STATE OF NORTH CAROLINA
DEPARTMENT OF TRANSPORTATION

August 3, 2006

Subject: Application for Modification to Section 404, Section 401 permits and Neuse Buffer Certificate for the Knightdale Bypass-- US 64 from I-440 (Raleigh Beltline) to existing US 64 near SR 1003, I-440 from 0.83 mile south of US 64 to Poole Road and a portion of the East Wake Expressway from existing US 64 to the proposed US 64 Bypass in Wake County. State Project No. 8.142202, Federal Aid Project No. NHF-DPI-0199 (004), TIP No. R-2547 (Sections BA, BB, C and CC) and R-2641, \$475 Debit Work Order 8.142202, WBS Element 34455.1.7.

The purpose of this submittal is to request a modification to the Section 404 permit and the Section 401 Water Quality Certificate/Neuse Buffer Certification, specifically for the stormwater/hydraulic design at several sites. All of the issues on Section BB, C and CC involve the installation of additional riprap to provide stability to problem areas on the site. The following is a description of the modification that is proposed at each site.

SHEET 20 OF 25 *Rev.*  
5/6/2006

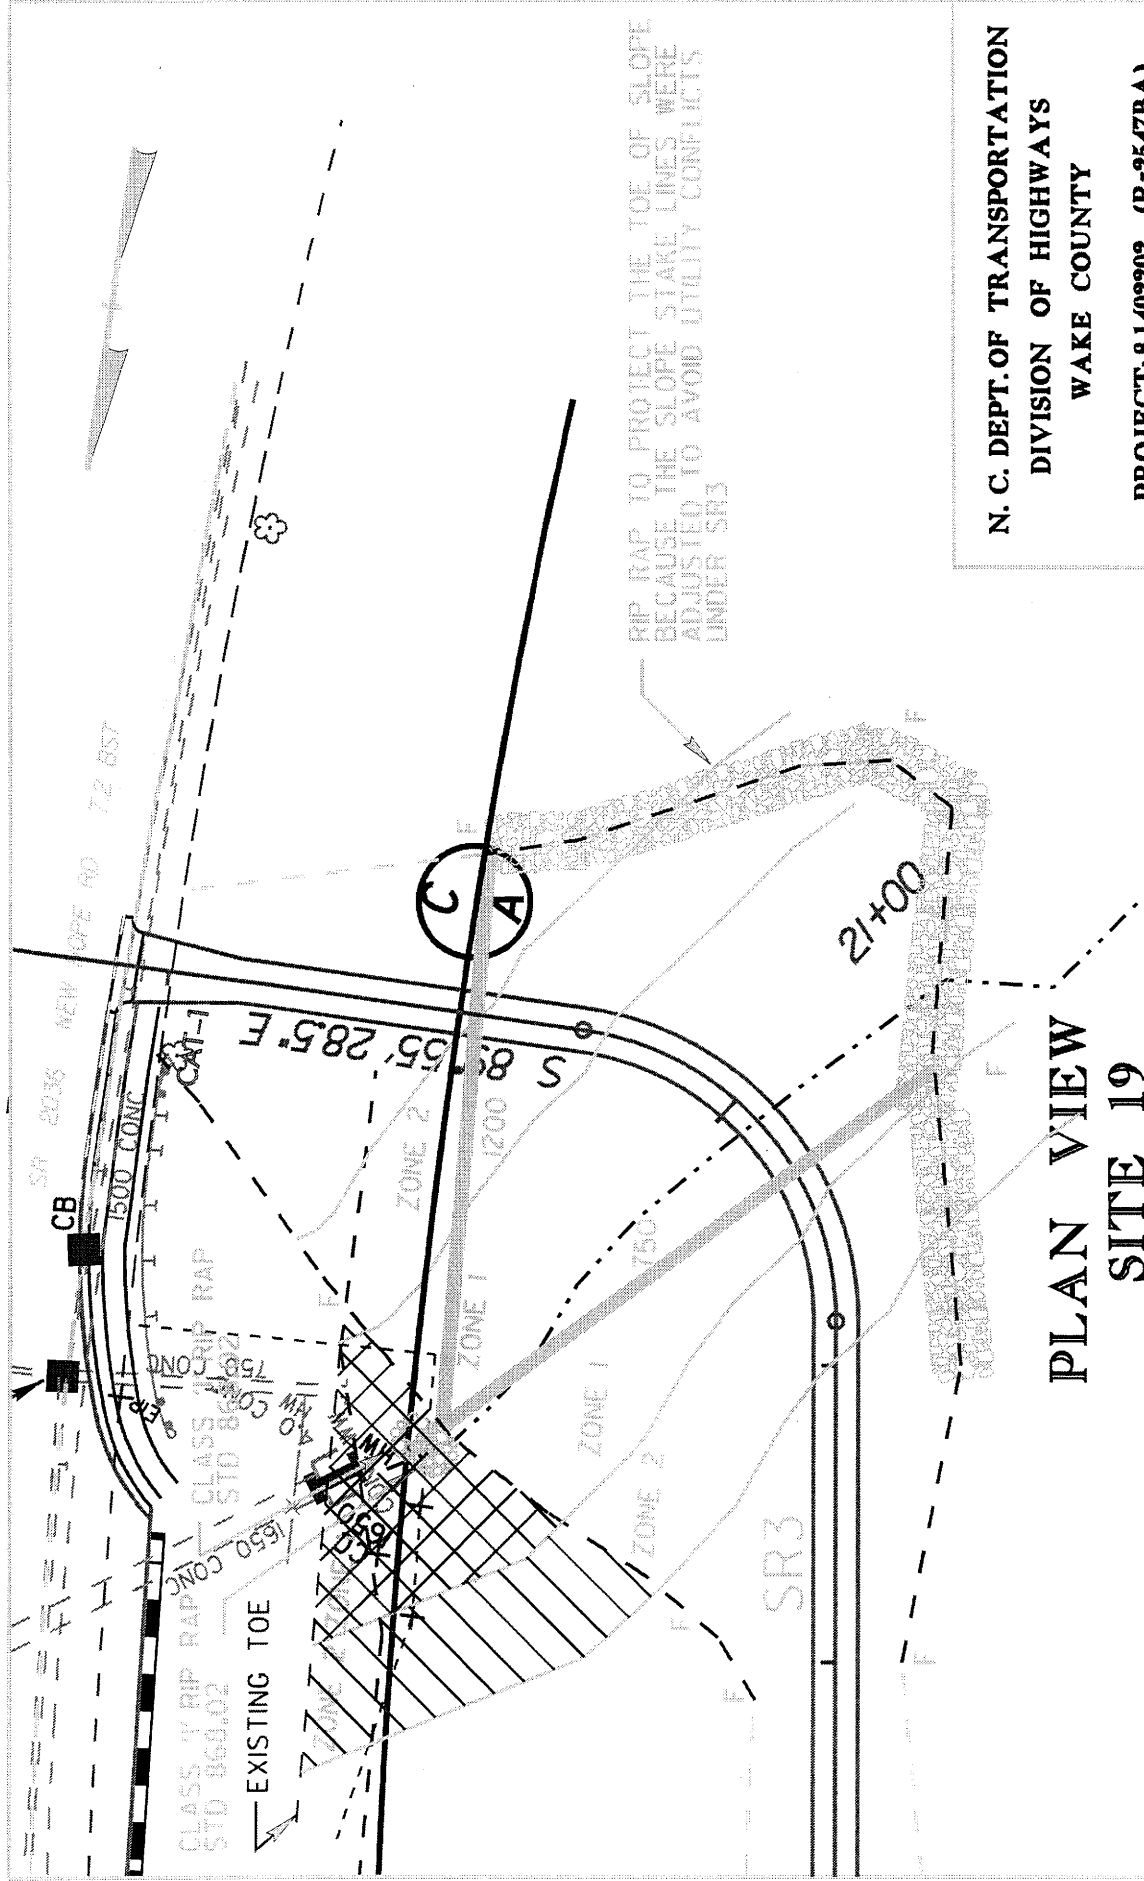
Issue: A rip rap pad located at the outlet of a 400 mm structure has been replaced with a pre-formed scour hole.

Resolution: The device has been installed within the transportation facility of old New Hope Road.

Additional buffer impacts do not occur as a result of this change as all construction activity associated with this issue is located within the transportation facility of old New Hope Road.

N. C. DEPT. OF TRANSPORTATION  
 DIVISION OF HIGHWAYS  
 WAKE COUNTY  
 PROJECT: 8.1402202 (R-2547BD)  
 US 64 BYPASS FROM NEW HOPE  
 ROAD TO EAST OF SR 2601  
 CLIFTON ROAD  
 SHEET 5 OF 30 REV 6/28/06

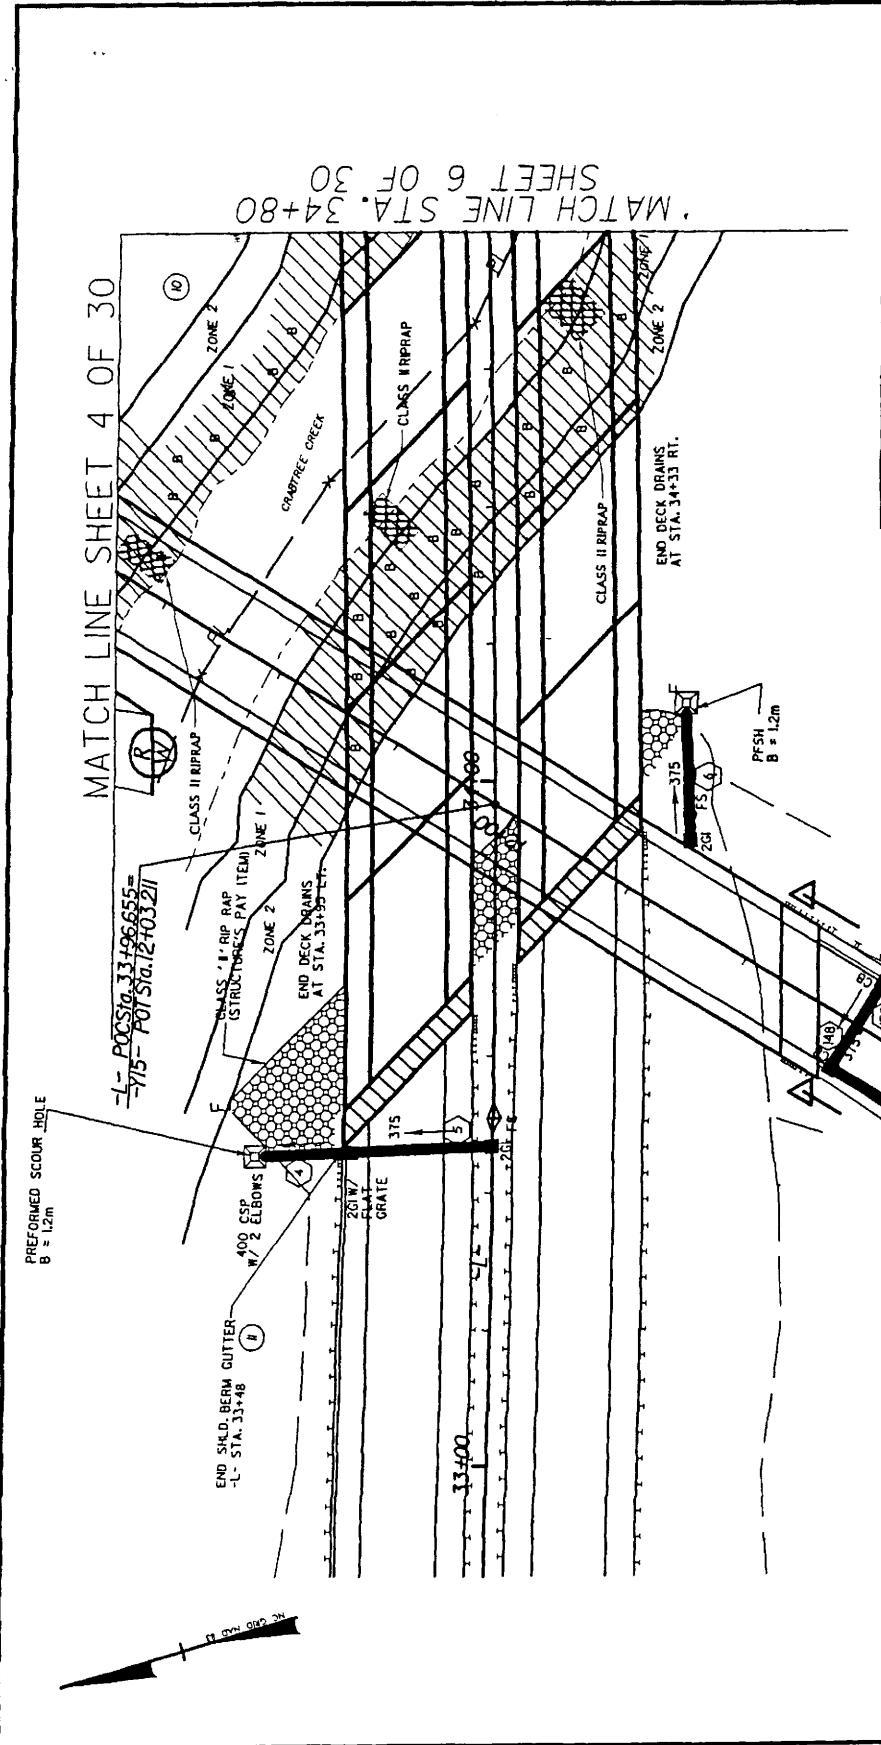
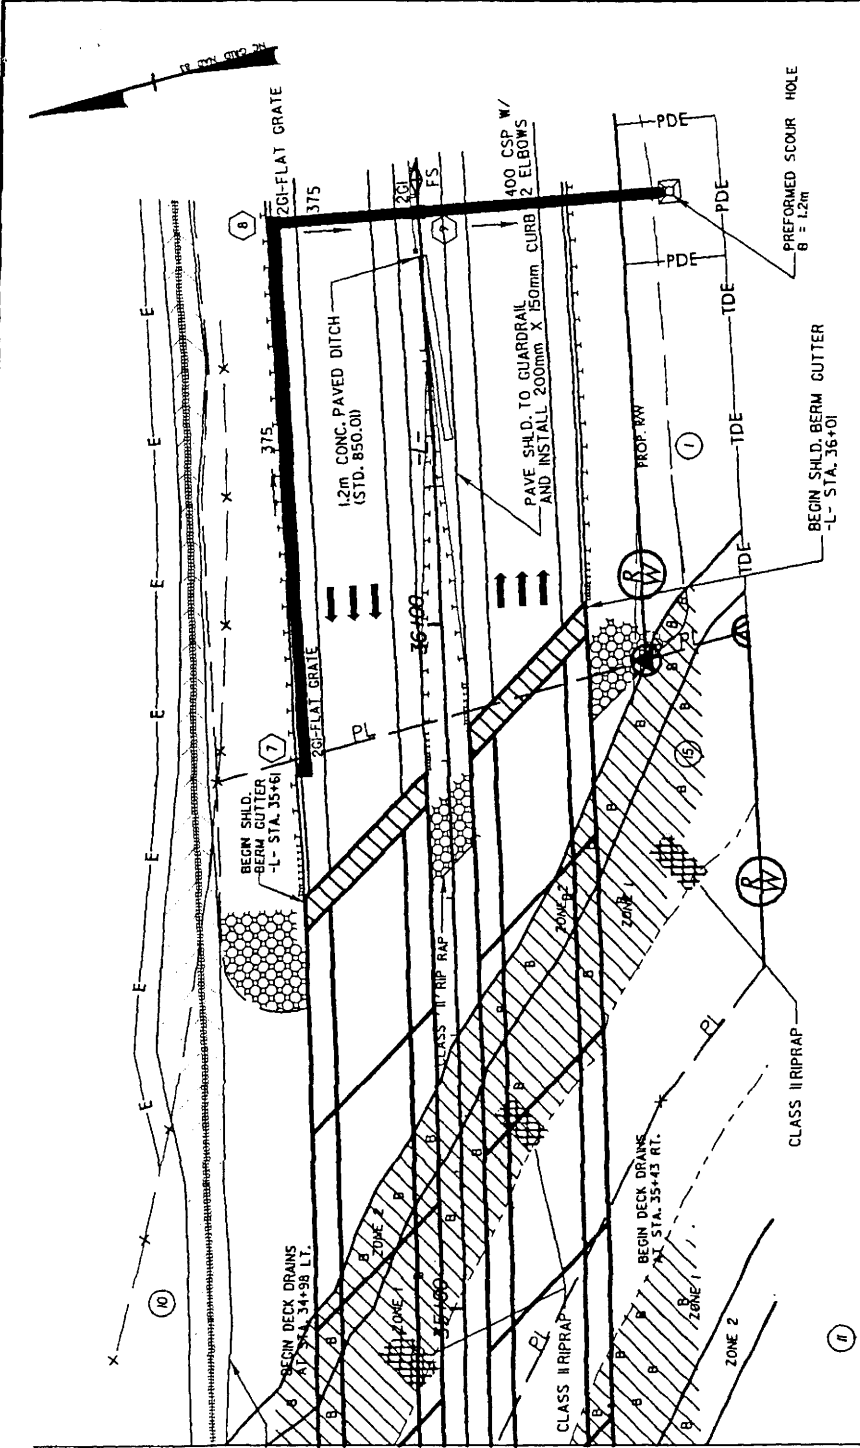
Issue: Stream bank erosion has occurred in six locations mainly due to lack of vegetation, erosion from high flow stream events, and lack of sunlight and rainwater to provide habitat for vegetation.

Resolution: Class II riprap with filter fabric is proposed to permanently stabilize these areas. Class II riprap is necessary due to the steepness of the banks and to withstand the stream velocities.

Additional impacts occur as a result of this change as the riprap will be placed below the normal water surface of the stream on the banks. The additional impacts are 0.007 acres (0.0030 hectares) of fill in surface waters and 89 linear feet (27 linear meters) of stream impacts. Additional stream mitigation is not required for this activity based on agreements made at a site visit with DWQ, USACE and NCDOT on May 22, 2006.

N. C. DEPT. OF TRANSPORTATION  
 DIVISION OF HIGHWAYS  
 WAKE COUNTY  
 PROJECT: 8.1402202 (R-2547BB)  
 US 64 BYPASS FROM NEW HOPE  
 ROAD TO EAST OF SR 2601  
 CLIFTON ROAD  
 SHEET 17 OF 30 REV 6/28/06

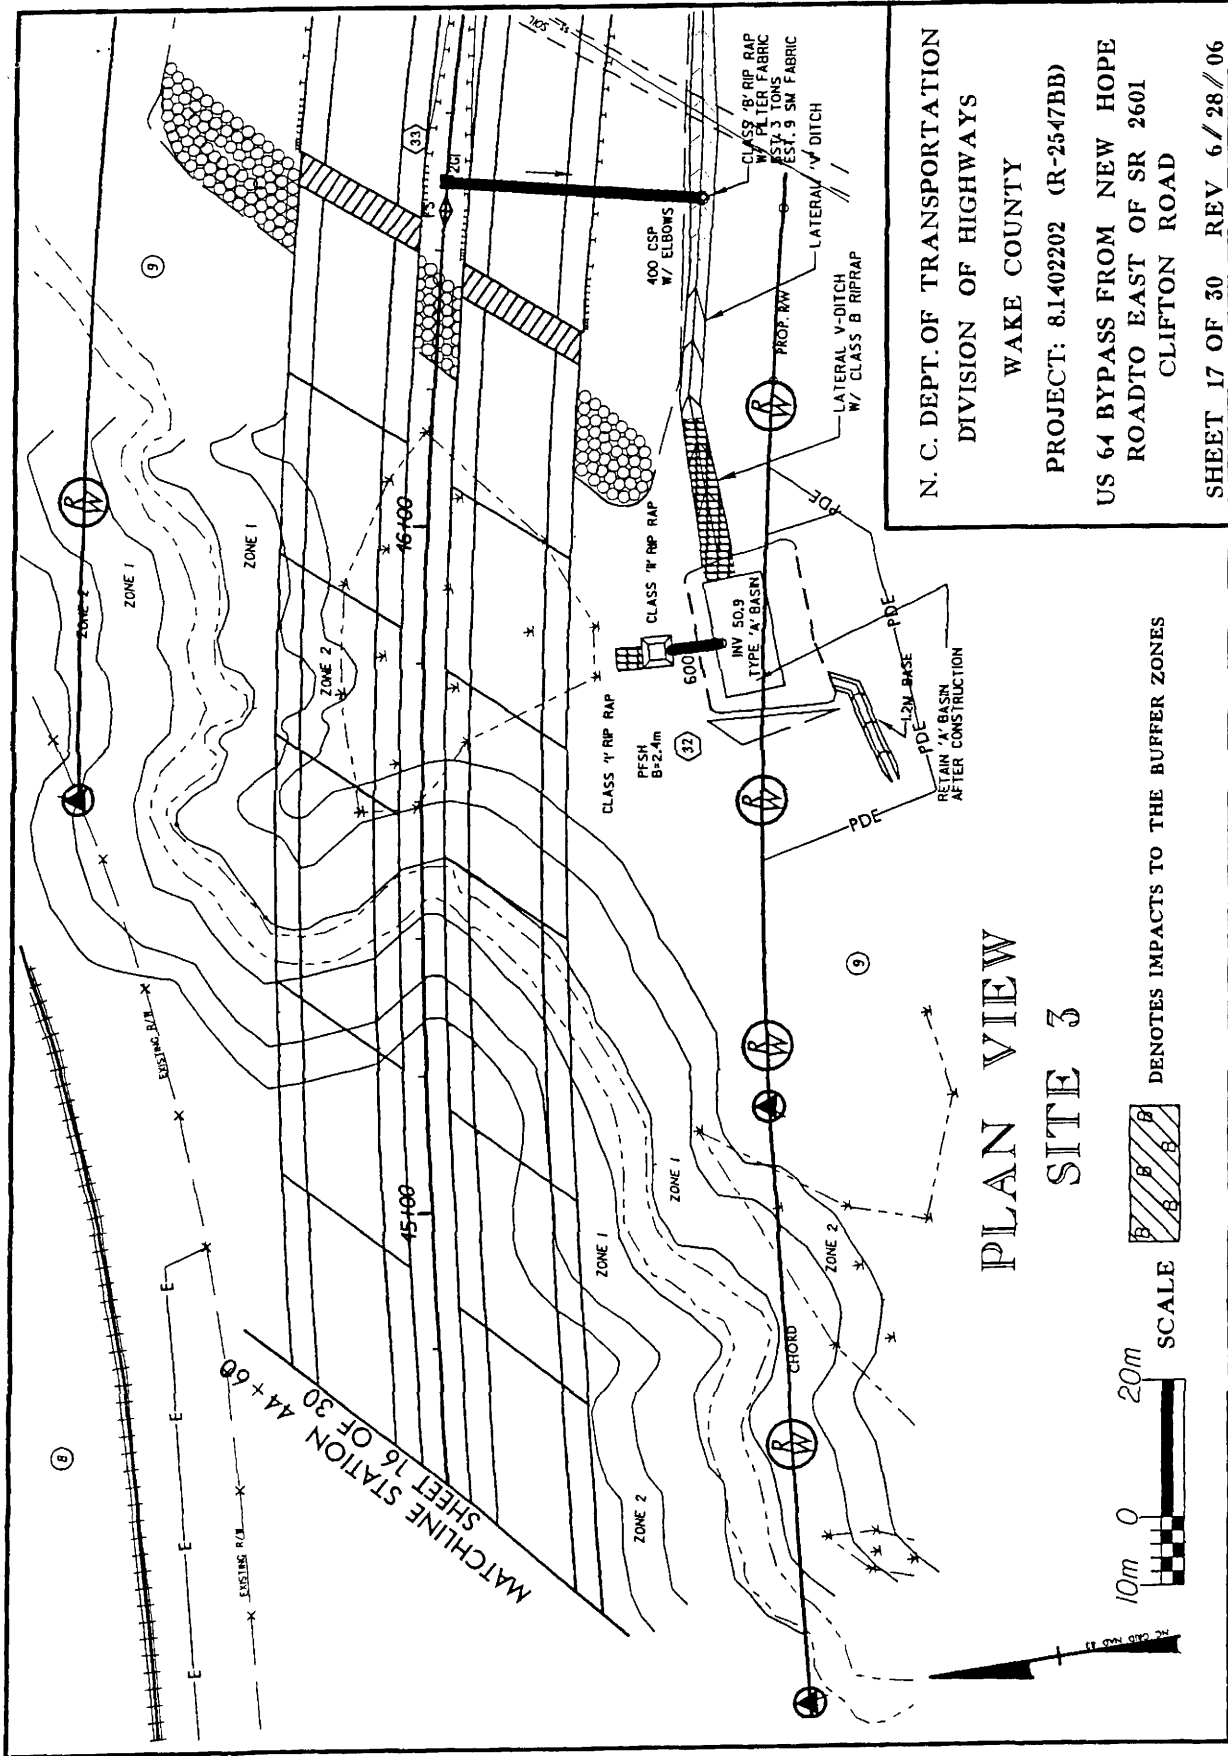
Issue: On the downhill side of the preformed scour hole, which is located at the outlet of the Type-A detention basin, stability of the area has been a problem.

Issue: Where the v-ditch enters the Type-A detention basin, the ditch is unstable and has eroded.

Resolution: The added riprap apron permanently stabilizes the area and provides non-erosive velocities at the wetland limits.

Resolution: Regrade the ditch and line with Class 'B' riprap from the A-basin to the fencing to permanently stabilize the area and prevent further erosion.

N. C. DEPT. OF TRANSPORTATION  
DIVISION OF HIGHWAYS  
WAKE COUNTY  
PROJECT: 8.1402202 (R-2547BB)  
US 64 BYPASS FROM NEW HOPE  
ROAD TO EAST OF SR 2601  
CLIFTON ROAD  
SHEET 23 OF 30 REV 6/28/06

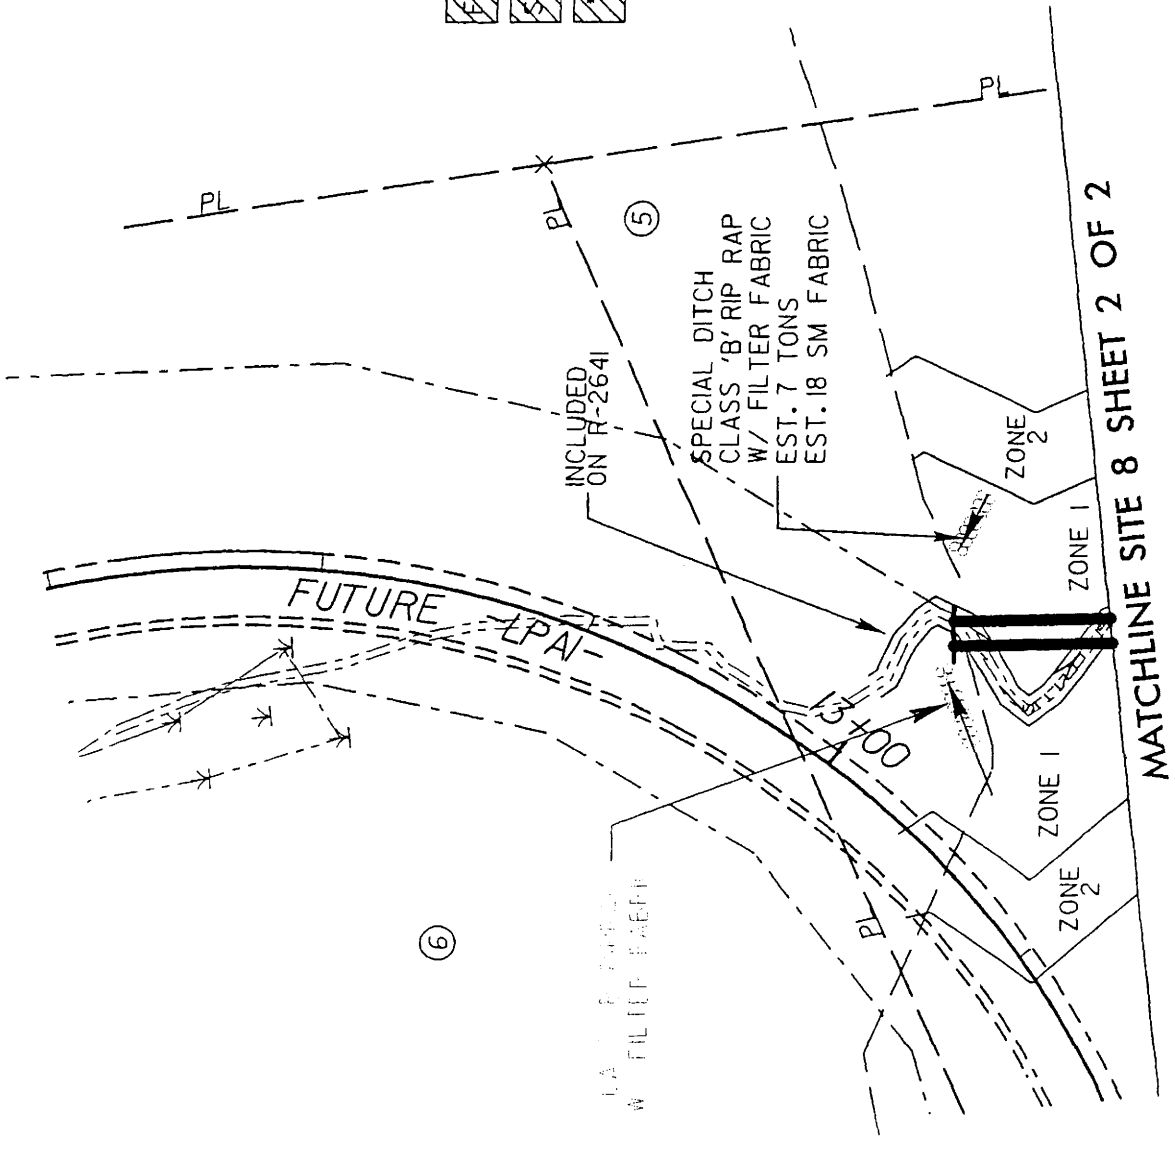
Issue: Class 'B' riprap has been added to the cut ditch where the ditch ties to the stream to provide stability.

Resolution: The added riprap permanently stabilizes the area and eliminates erosion problems at the site.

SHEET 13 OF 24 REV 6/28/06

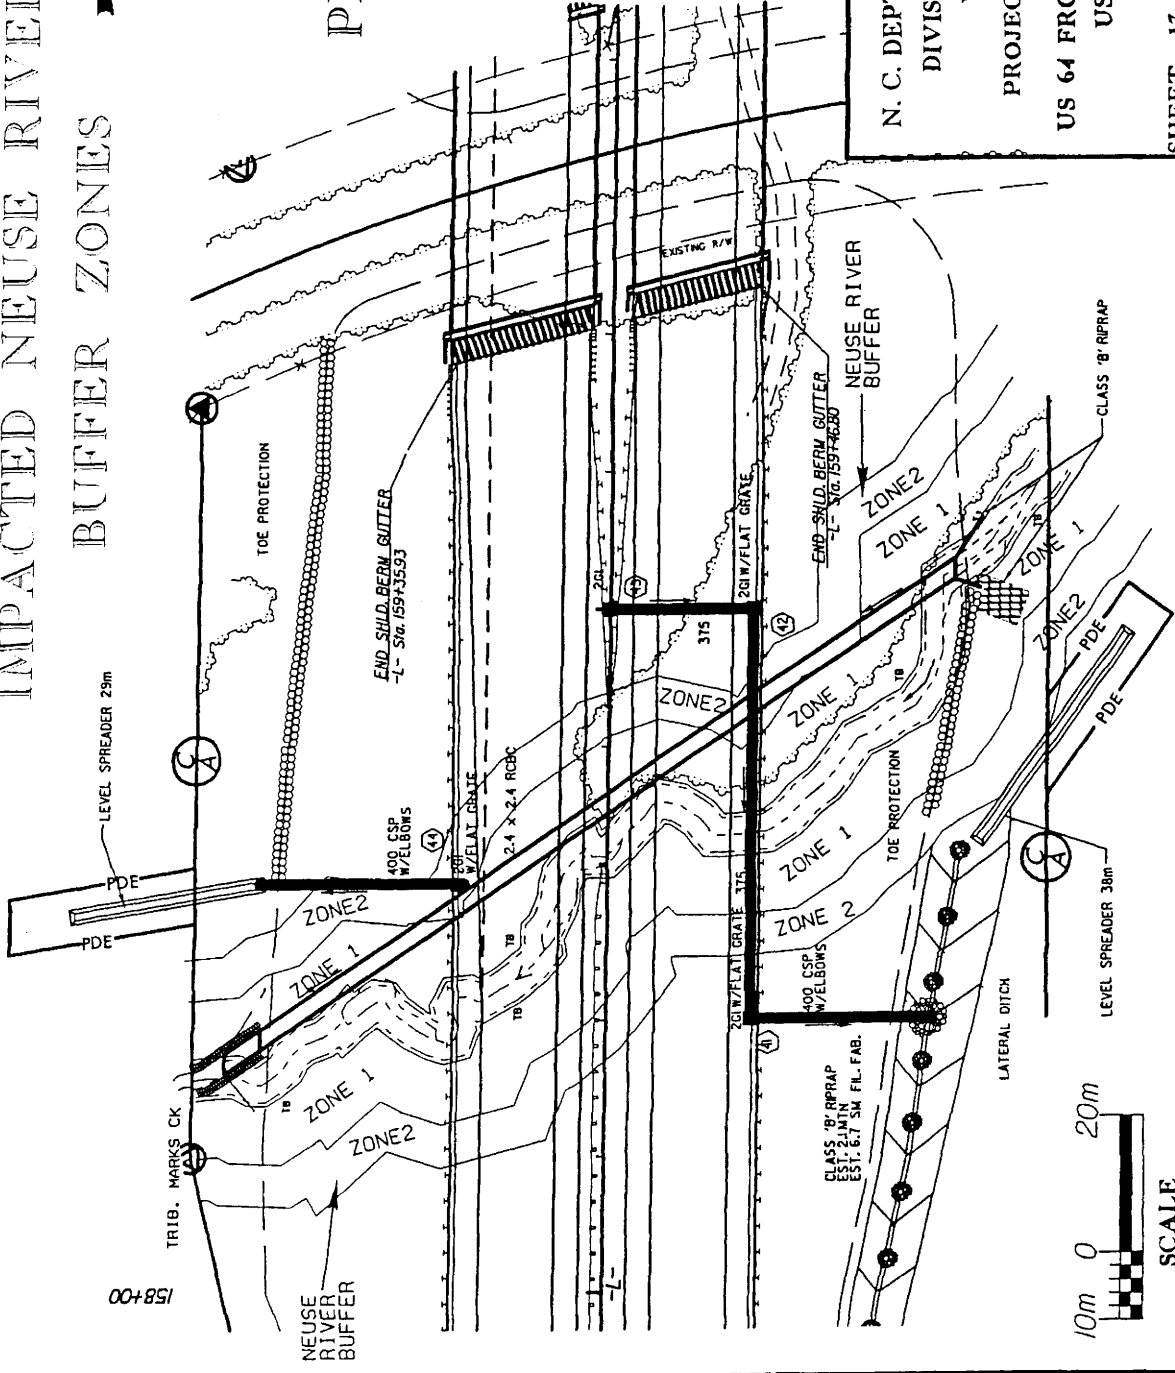
Issue: Instability on the south stream bank has been a reoccurring problem at the culvert inlet.

Resolution: Riprap has been installed along the streambank and within the riparian buffer to provide long-term stability.
